Planning application 23/02098/OUT

OBJECTION

The application and initial comments considered at the meeting of Begbroke parish council 04/09/2023

Figure 2.4: Existing Public Rights of Way Network

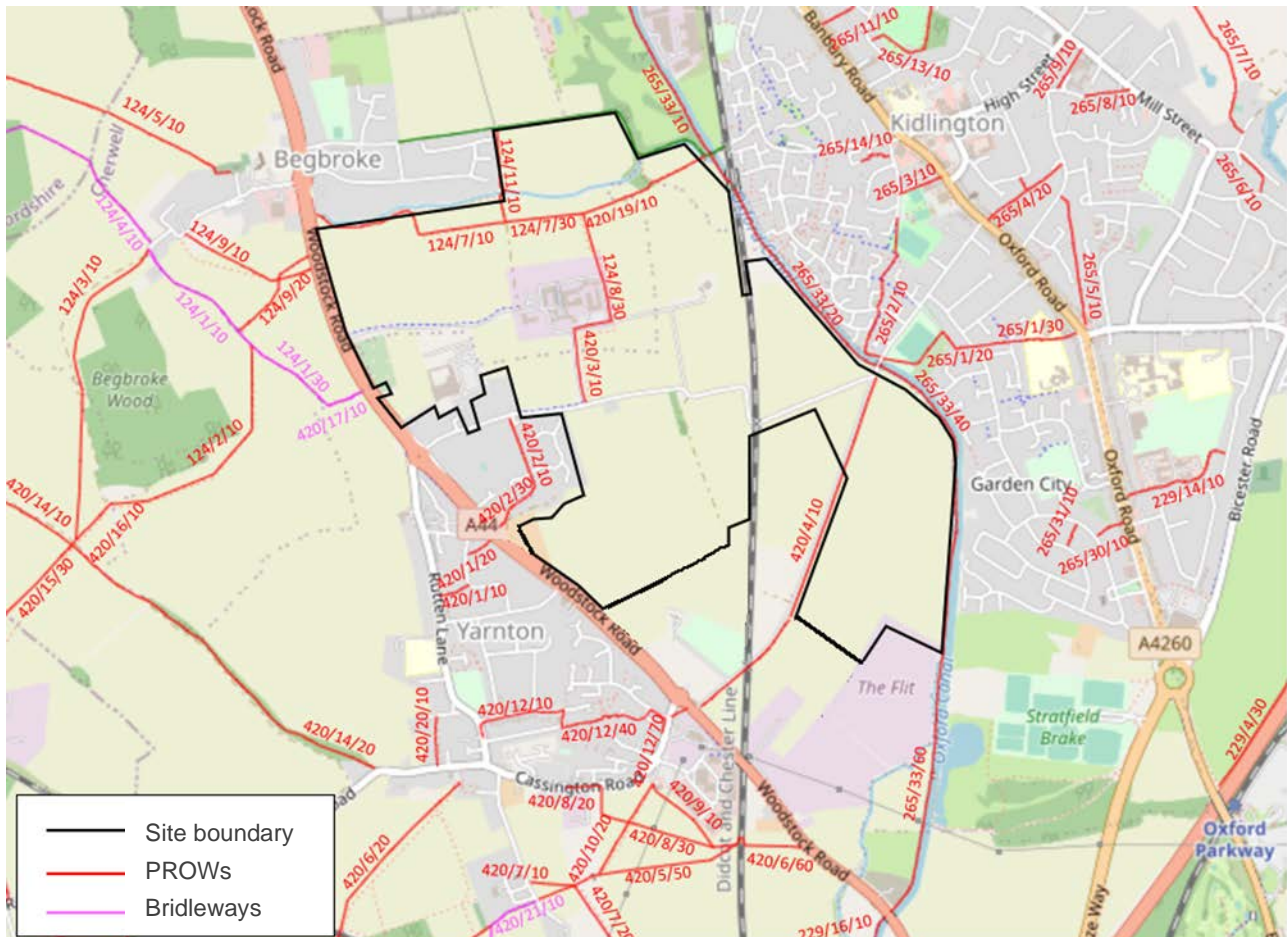
- Concerned that the University or OCC Countryside services has little regard for existing footpath rights – especially having changed existing paths –124/8/10 (4ft width along whole length of path; 124/7/20 8ft wide -Kidlington inclosure award; 420/19/10 & 265/22/10 8ft wide Kidlington inclosure award – into a shared cycle path/pedestrian routes (RUPP) without any apparent legal basis. The section up to the junction with FP 8 has some parts divided with cycle signs and other sections, the full width as a shared path with signage to that effect.
- We understand from our research, that the correct procedure should have been to maintain the existing footpath width, provide an adjacent cycle path if a cycle track order is not involved and not make the existing path shared use.

- We are concerned that similar work may occur on other paths on the site and in some instances provide vehicular access such as to the Community Farm and allotments to the north of the site.
- A risk assessment was requested for the footpath work but not supplied.
- There has been an incident of two motorcycles using the tarmac surface.
- A recent incident reported to us involved a skateboarder who fell off on 12/4/8/10. An ambulance was called and we understand he was carried off on a stretcher.

Figure 16.6: EA flood maps for planning shows present day flood zones

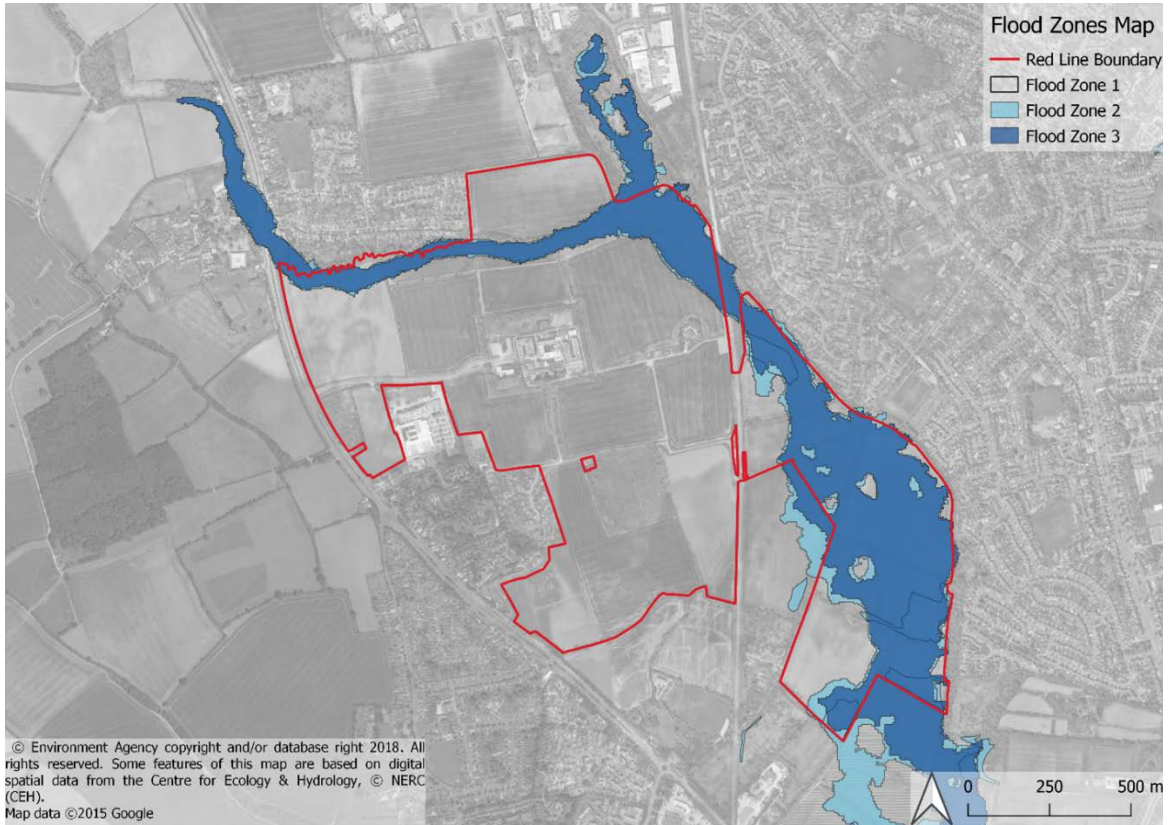
- In areas adjacent to Rowel Brook in the north, and land east of the railway, there are areas identified as either primarily Flood Zone 2 and Flood Zone 3. The remainder of the site is shown as Flood Zone 1. It appears that the proposed Rowel Brook Park is exactly on the flood zone and accompanying images demonstrate this.
- Cannot find that any account has been taken of rainwater from the west namely Spring Hill and proposed PR9 development. This area floods and images can be provided. The parish council and residents are aware of the results of heavy rainfall.
- Report ES Vol 1 Chapter 16 16.5.55 acknowledges: The key areas at flood risk in all return events are: ♣ Sections of the Site along the length of Rowel Brook; and ♣ The parcel of land immediately to the west of the Oxford Canal
